# CITY OF ALBUQUERQUE

**Re: Slim Chicken - Albuquerque**  
**8240 Montgomery Blvd NE**  
**Traffic Circulation Layout**  
Engineer's Stamp 05-18-2022 (G19-D004E)

Sheet 5 of 8
210263

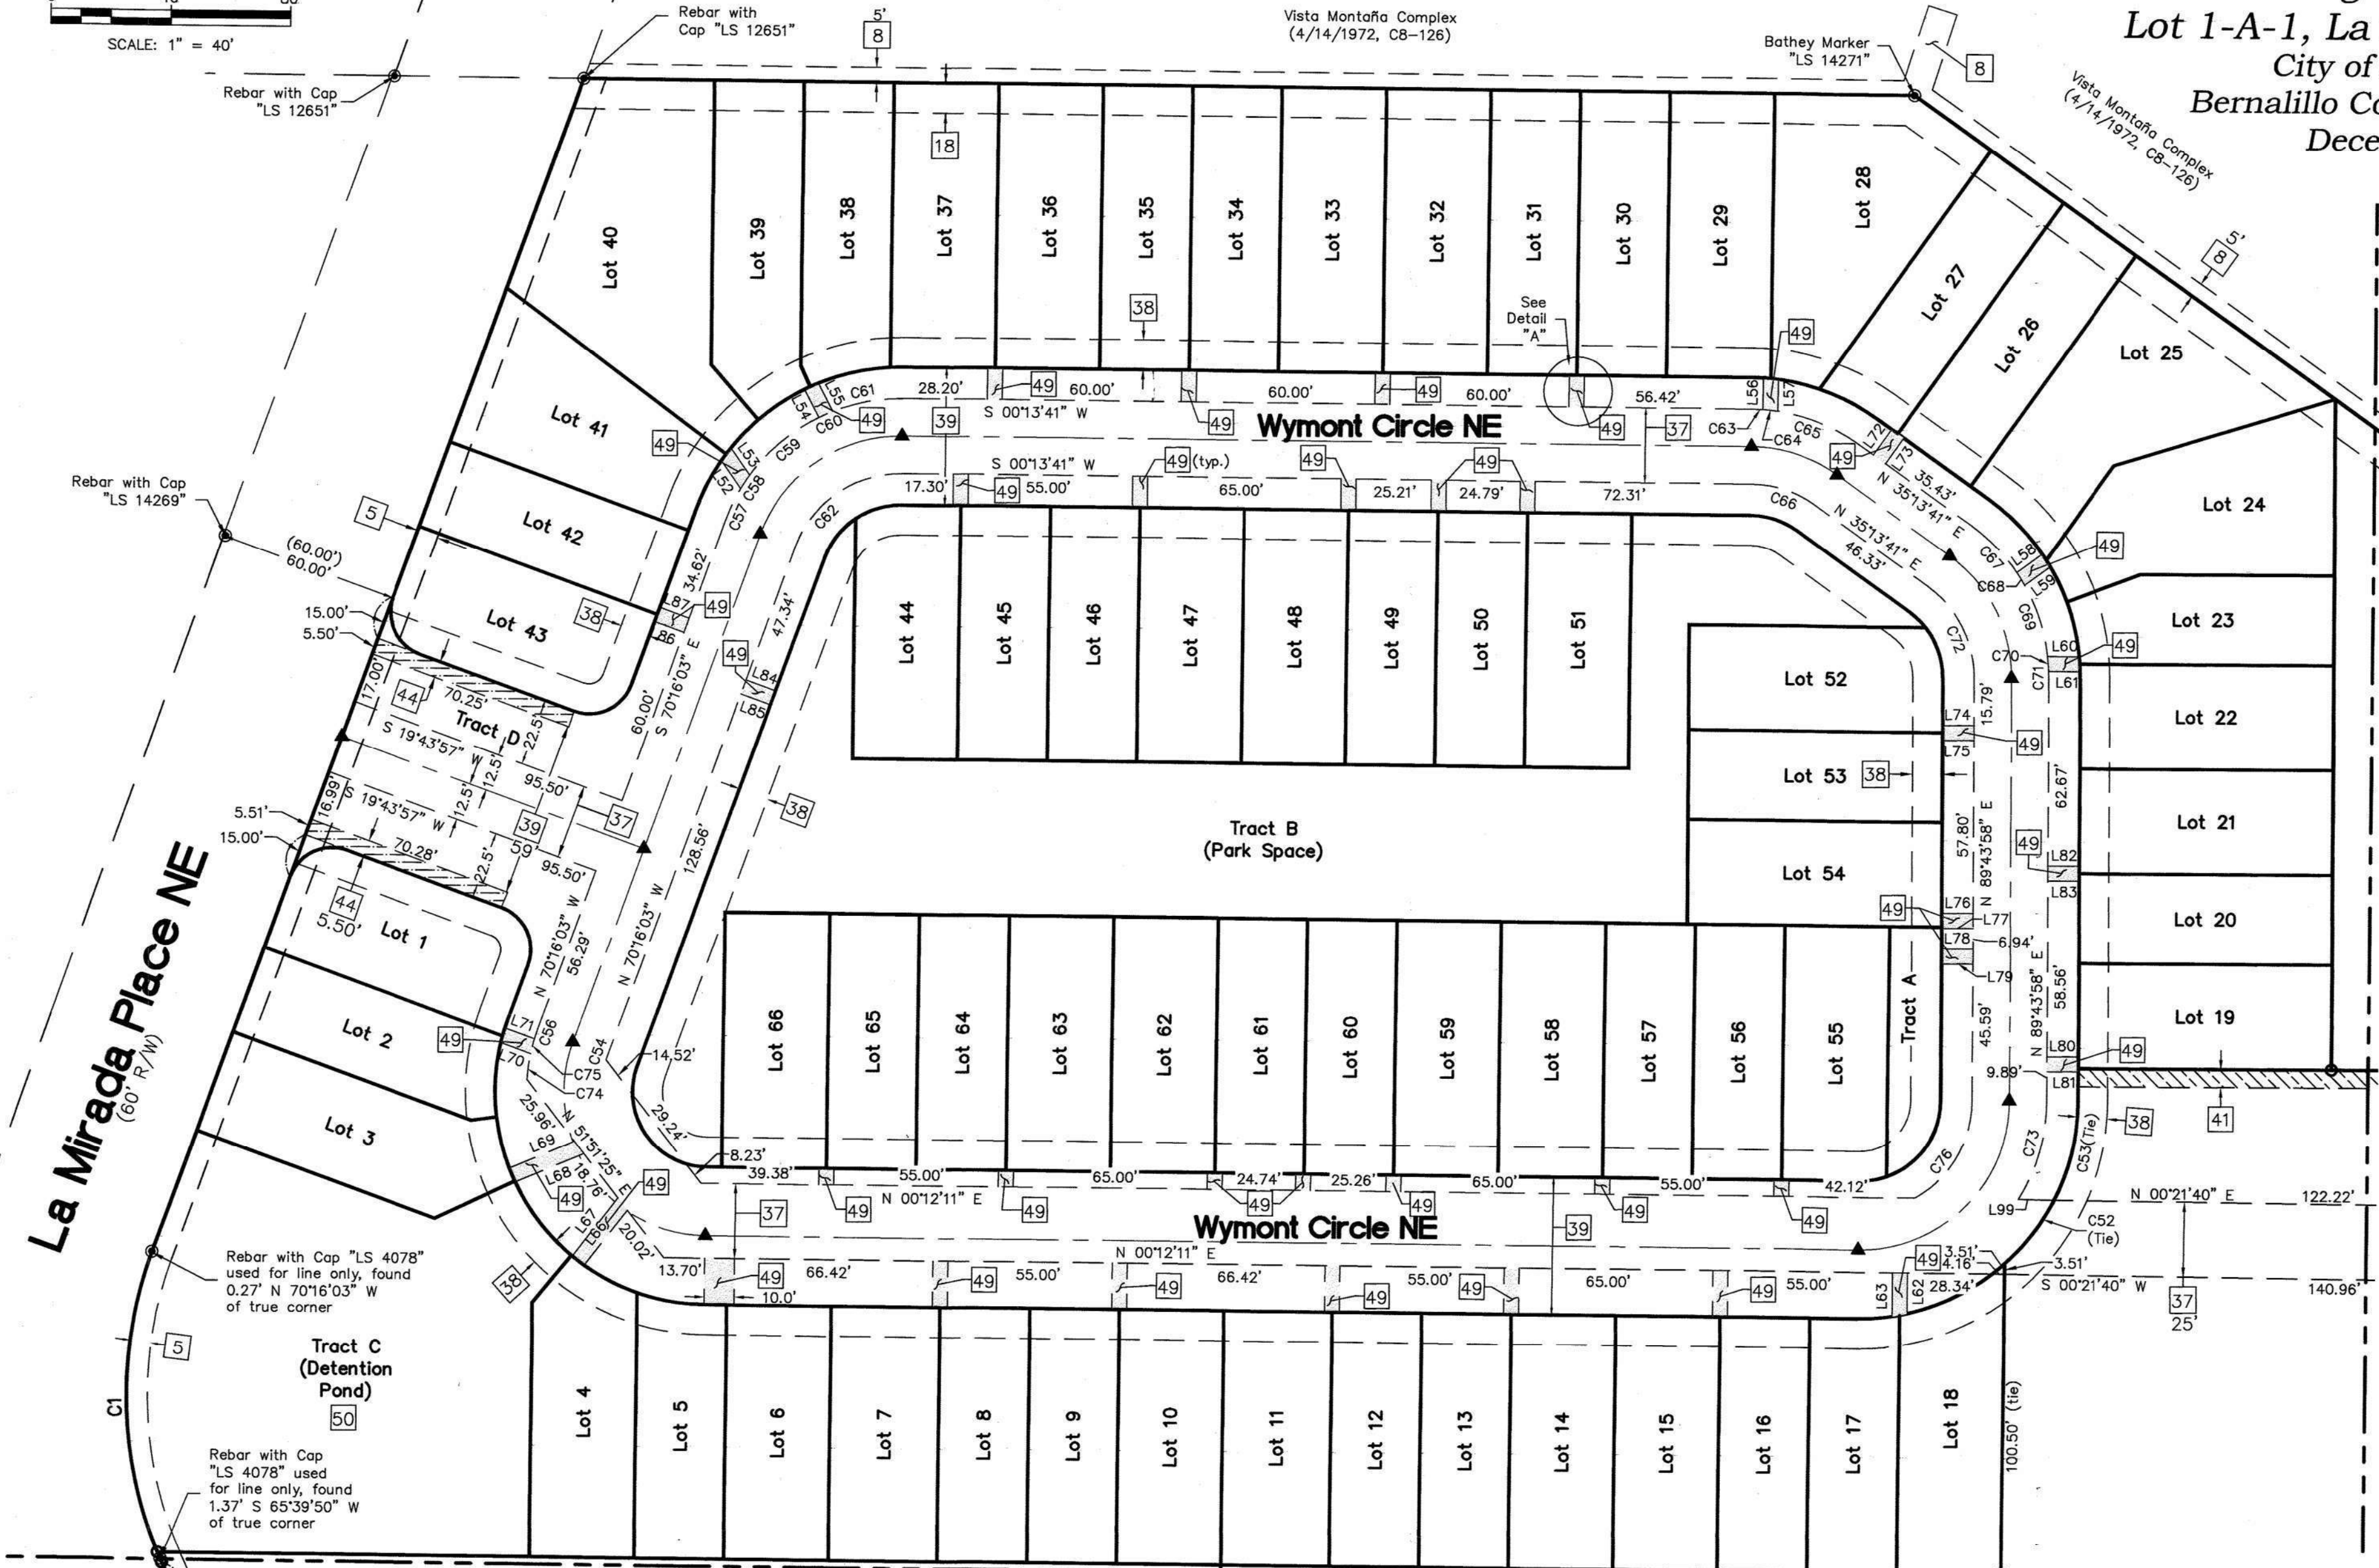
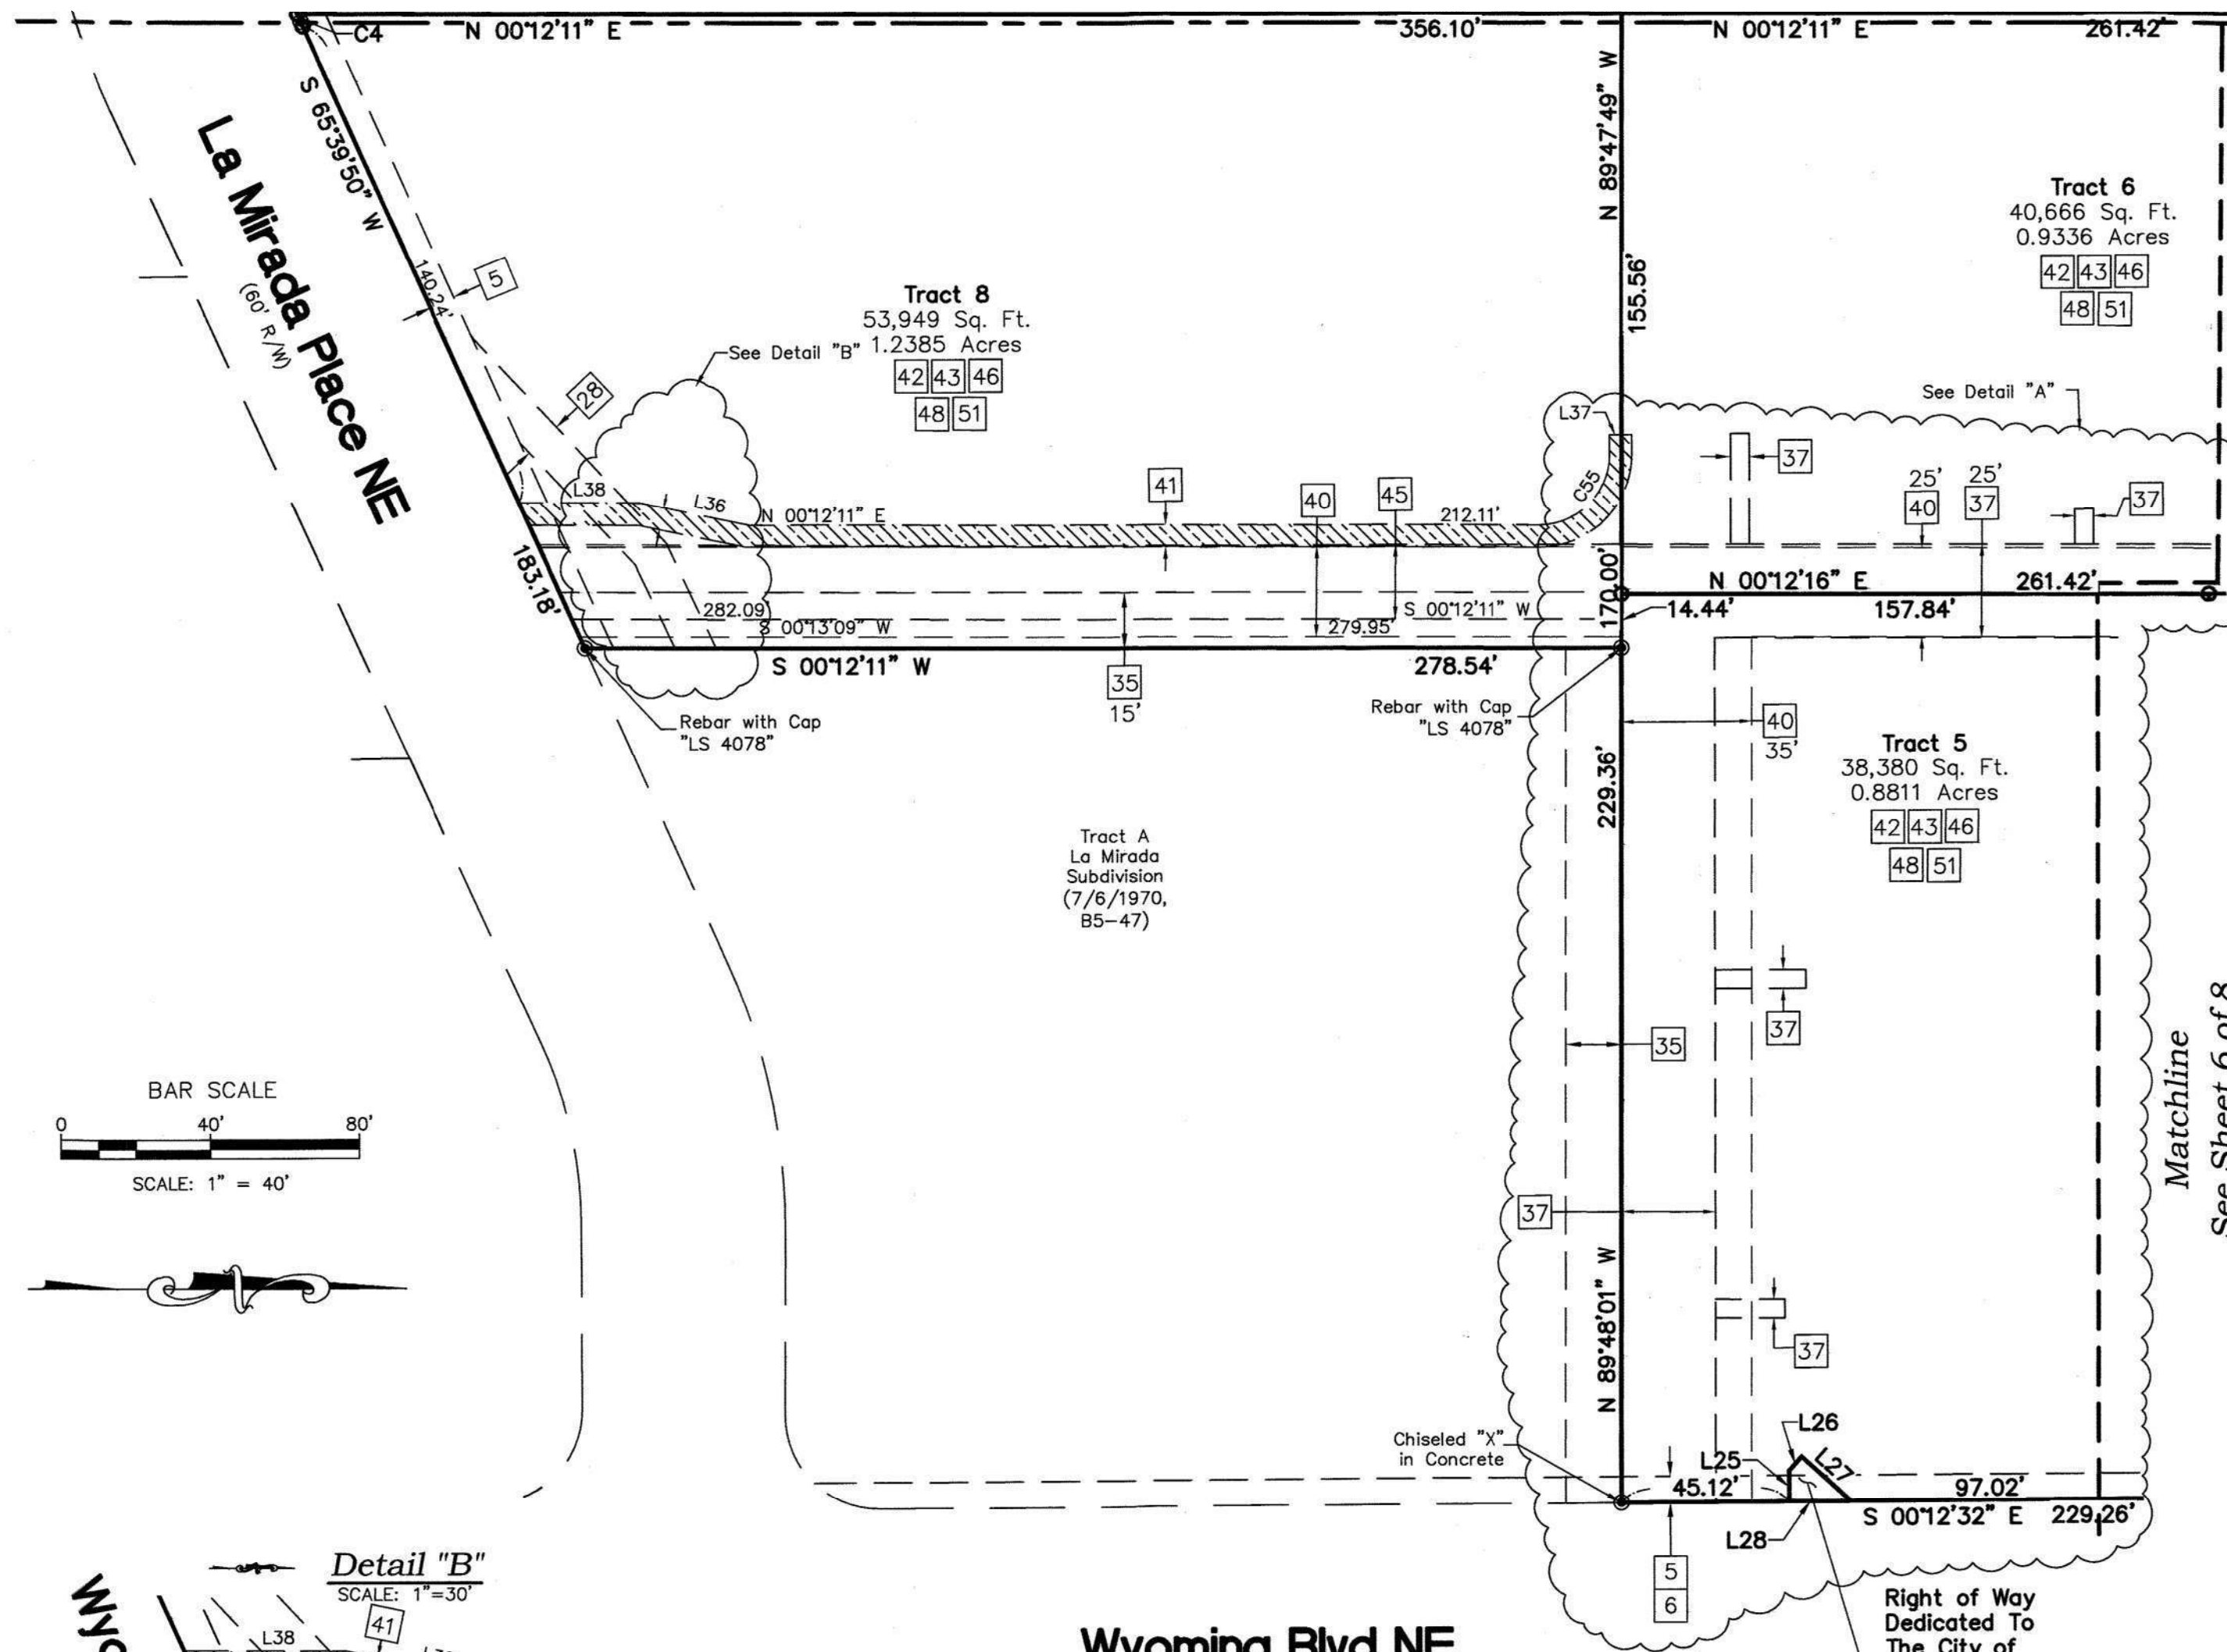
- The proposed drive aisle located mostly on tract 2. Please provide certified agreement with Tract 2 land owner.
- Plat for Wymont subdivision keynote 40: Private Rodway Easement should serve Tract 1-8. And on sheet 6 the location of driveway easement doesn't match the proposed drive aisle. The easement will need to encompass the proposed drive aisle shown on site plan. Please address this concern.
- Plat for Wymont subdivision keynote 41: Public sidewalk easement doesn't match site plan.
- Provide sidewalk connectivity to serve Tract 2.
- The main drive aisle will need striping for ingress/egress vehicles movement. Striping will be needed on the frontage segment of Slim Chicken.
